Engineers Comments Regarding Surface Water Drainage

Application Reference:	WA/51/26/RES	Reviewer Reference:	ADC/EXT5/AF
Planning Officer:	Simon Davis	Date of Review:	14/09/2026
Site Name:	Land East of Wandleys Lane Fontwell		
Application Description:	Approval of reserved matters following the grant of outline planning permission WA/35/23/OUT, for the construction of 95 No. new homes, access, new pedestrian and cycle links, open space, landscaping, habitat creation, drainage features and associated groundworks and infrastructure, including details relating to the Sensitive Lighting Strategy, POS details and Part M Compliance. This application is in CIL Zone 3 and is CIL Liable as new dwellings.		
Assessment Number:	2

Drawing Title
EXCEEDANCE FLOW ROUTES
SHEET 1 OF 2

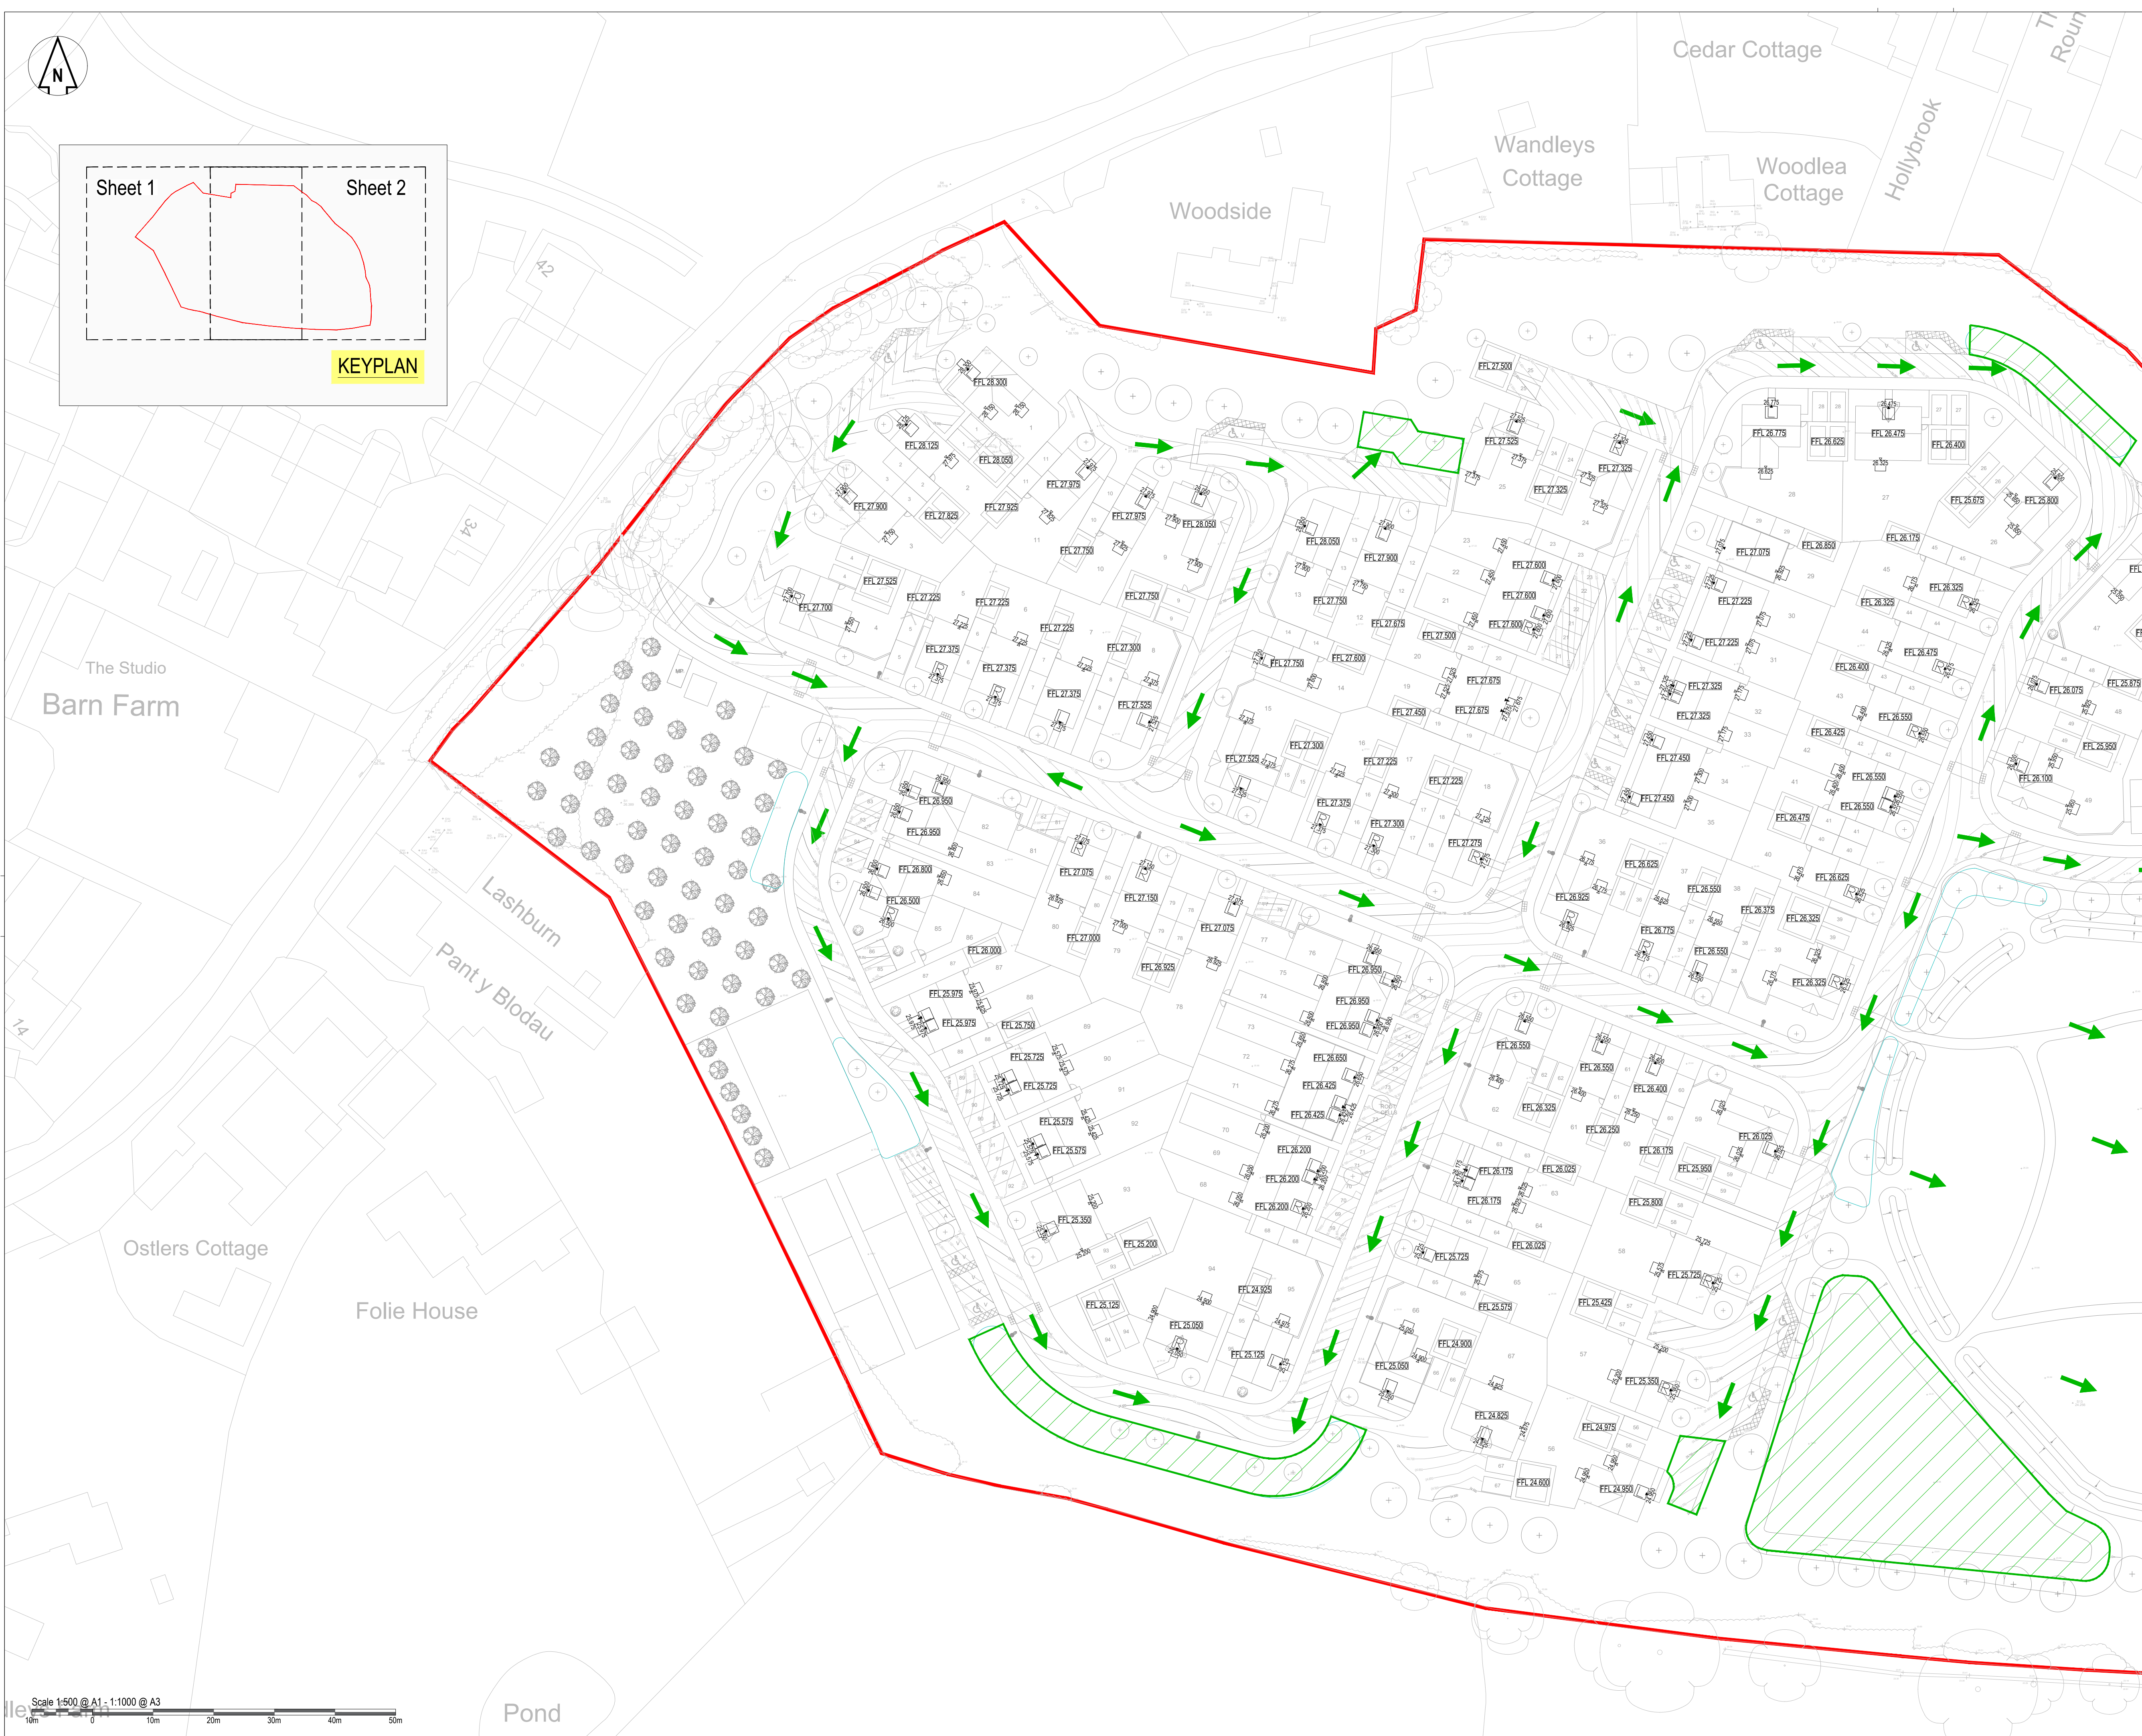
- 3.4. Exceedance paths are updated and acceptable subject to technical design of the proposed levels which can be presented at discharge of conditions stage.
